# CITY OF ALBUQUERQUE

March 28, 2018

RE: **Silver Star Auto Haus**  
**5111 Wilshire Ave. NE**  
**Engineer's Stamp Date: 3/19/2018**  
**Hydrology File: C17D014A1**

Based on the information provided in the submittal received on 3/20/2018 the above-referenced Grading and Drainage Plan cannot be approved for Site Plan for Building Permit until the following comments are addressed.

GRADING & DRAINAGE PLAN

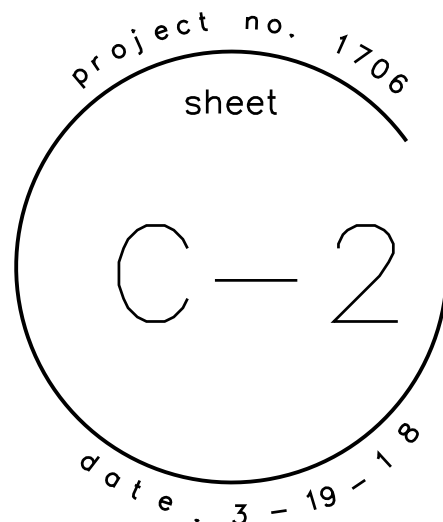
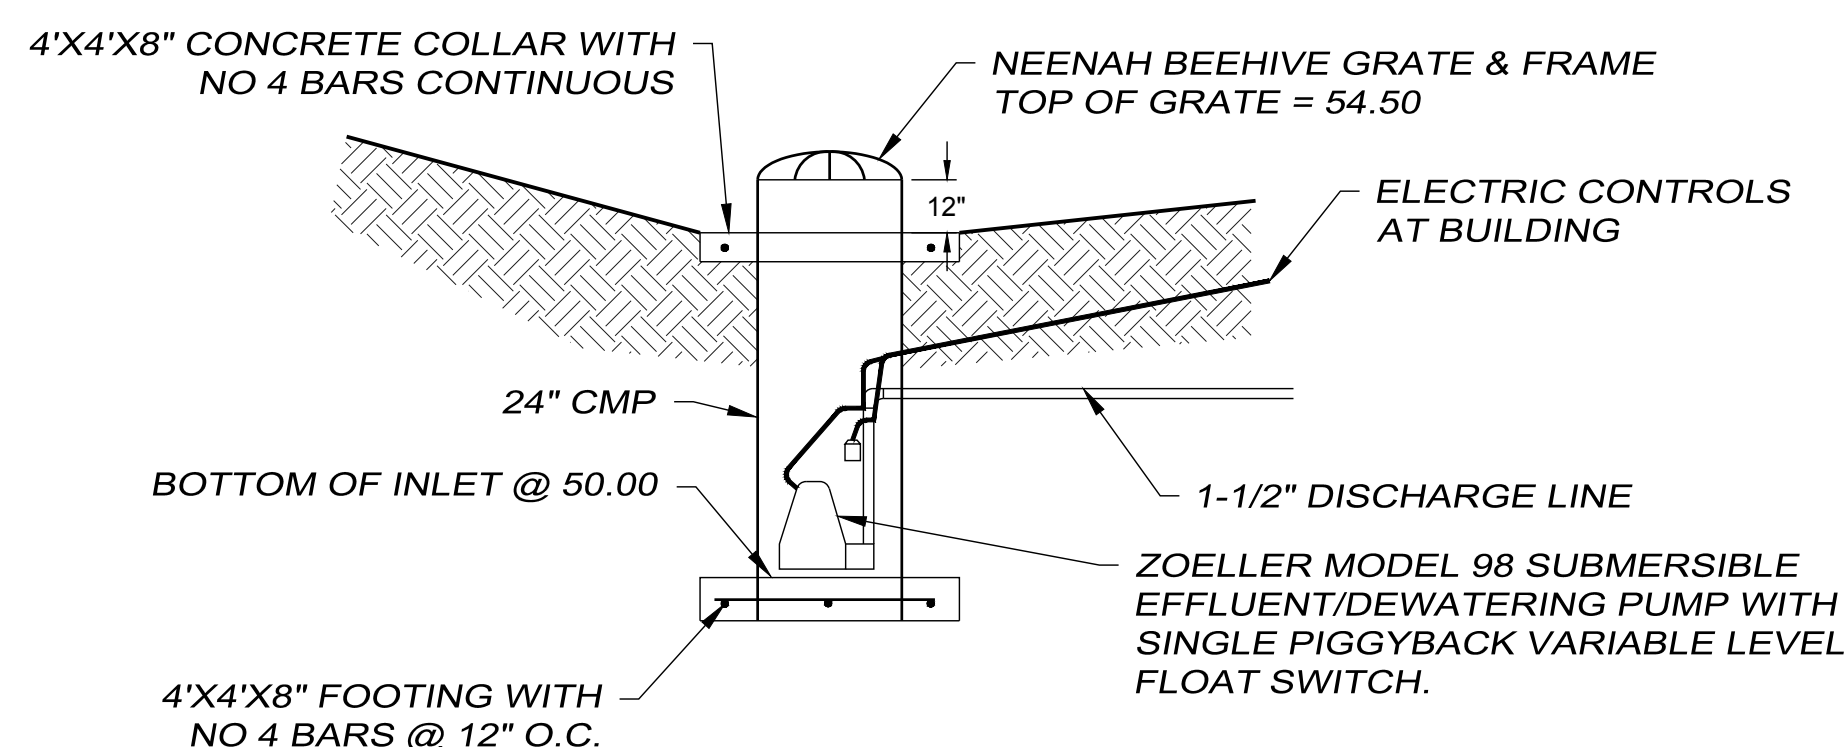
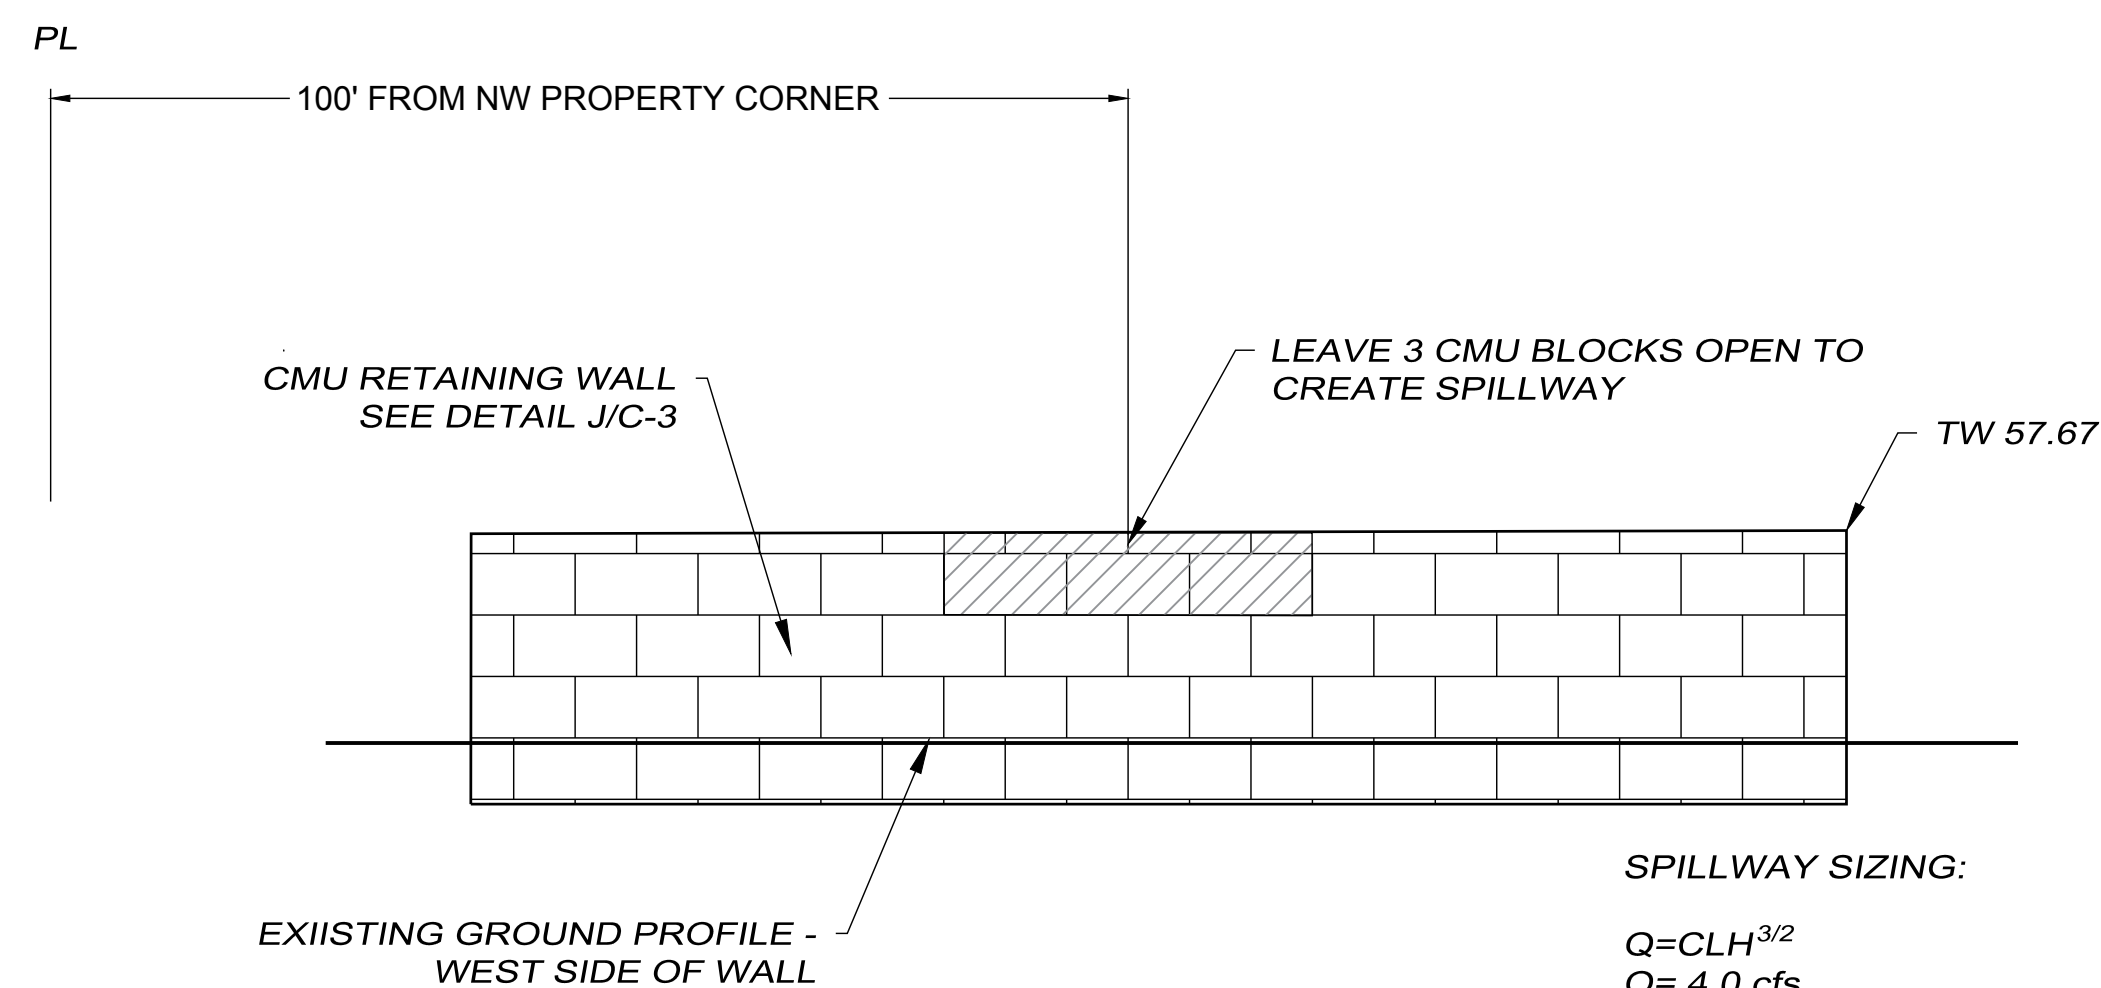
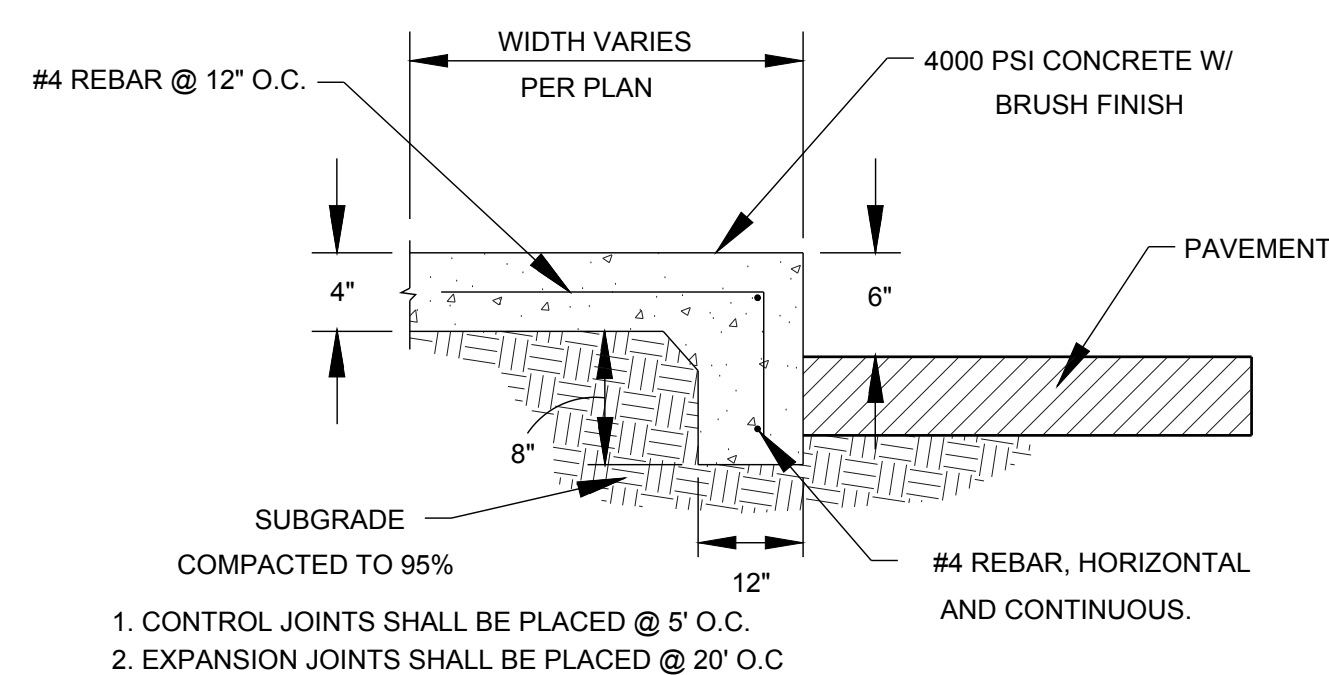
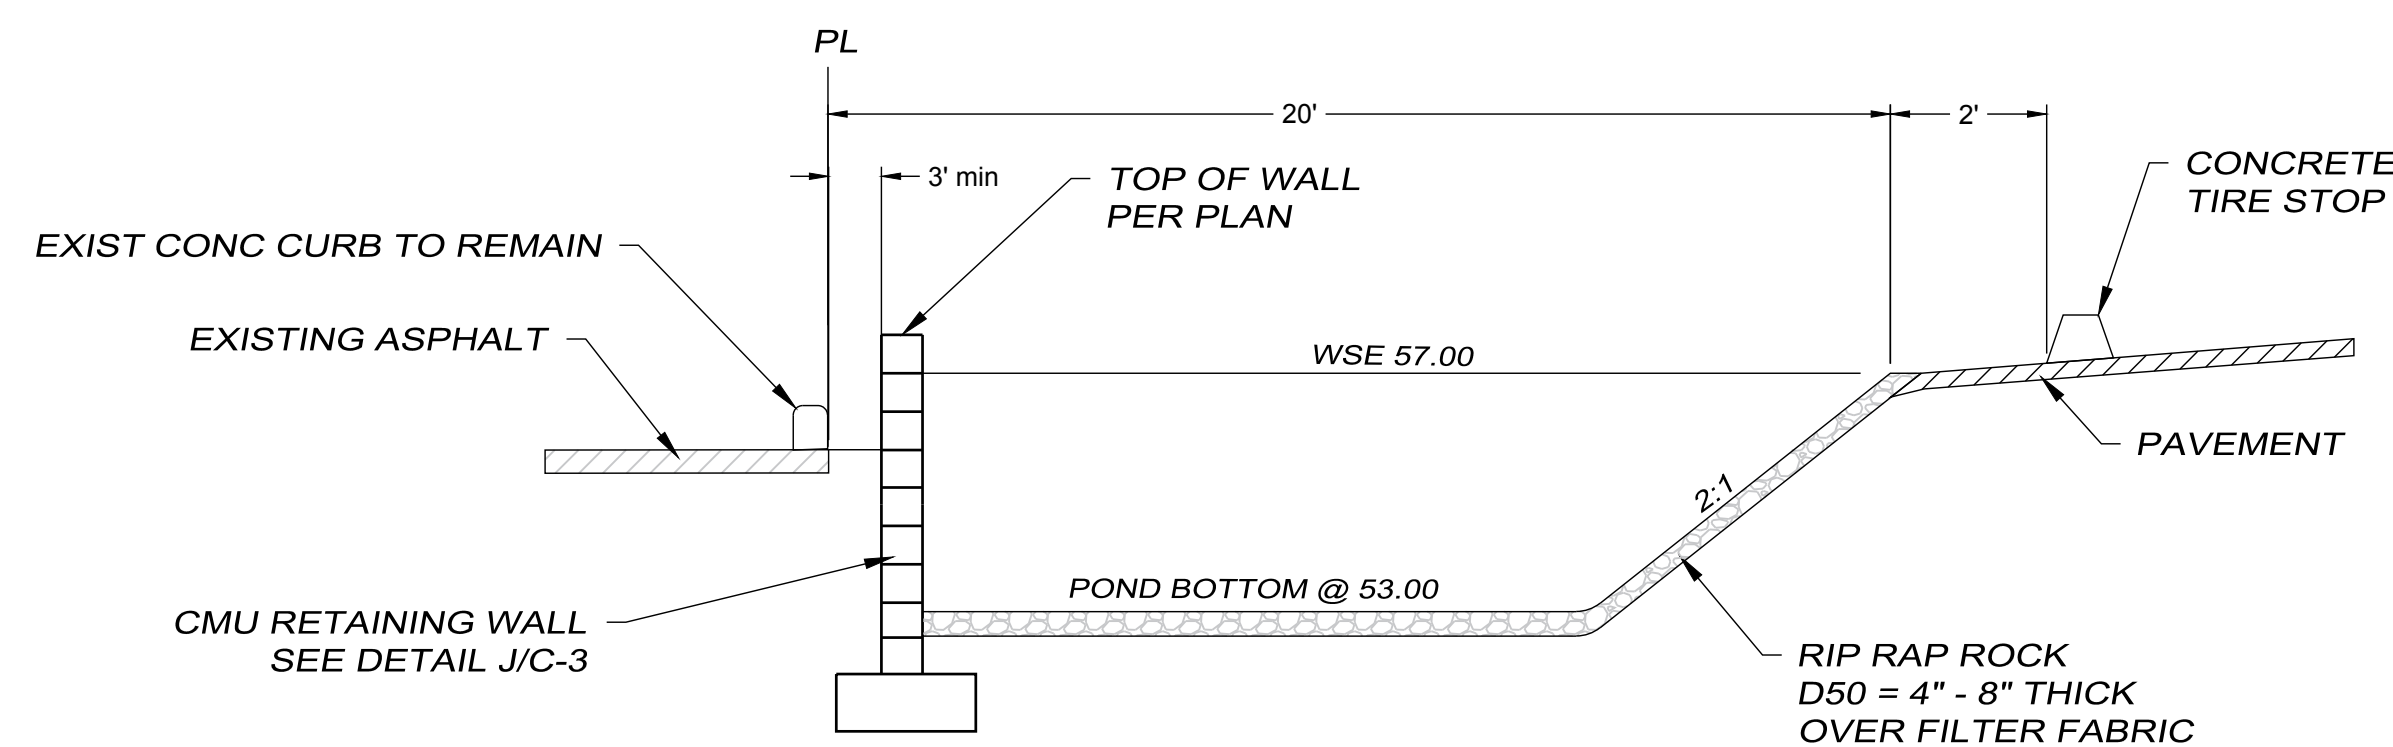
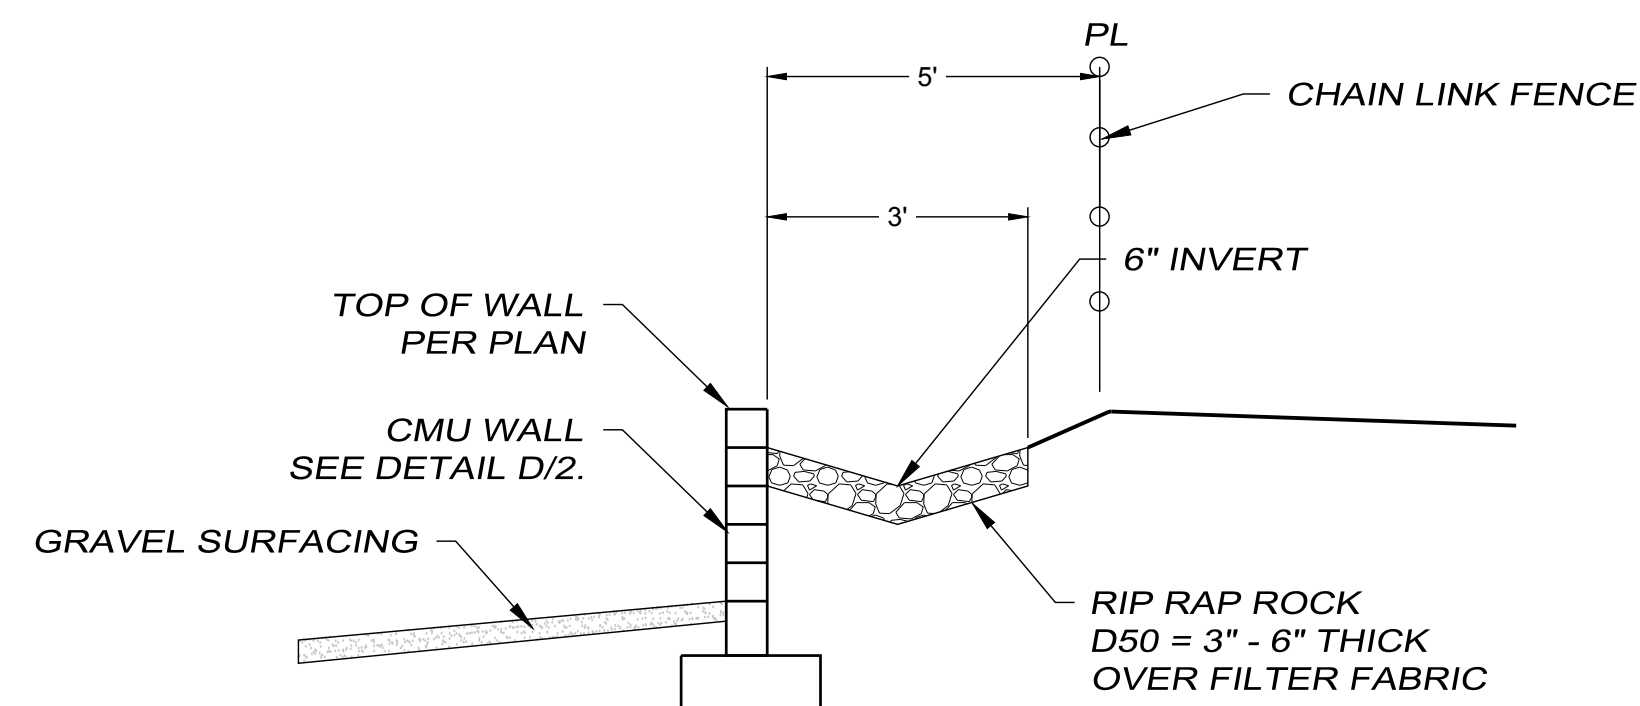
This plan can be approved for "Site Plan for Building Permit" by just changing the sheet title to "Conceptual Grading and Drainage Plan" and placing a bold label on the plan that says "Not for Construction". Alternatively if seeking approval of the plan for both "Site Plan for Building Permit" and for "Building Permit" then check both items on the DTIS and address the following additional comments.

2. An SO-19 permit is required for the connection of the private storm drain (force main) in the public right of way. The standard SO-19 notes must be added to the G&D Plan and check the "SO-19 Approval" line on the DTIS.

3. More information is needed on the typical sections thru the retaining walls on the west and east sides of the site to insure compliance with DPM 22.5.B "Care should be taken to ensure that existing foundations, retaining walls, stable slopes or other structures are not endangered and that the adjacent property is not damaged or its use constrained due to grading at or near the property line." Specifically dimensions should be added to the typical sections showing the maximum retained height of fill across the wall and horizontal dimensions from the property line to the closest edge of the footer as necessary to keep the footer out of the soil friction plain.

4. Pump specifications and performance curve are required. They should be added to the G&D Plan and the information should be included in the Drainage Covenant.
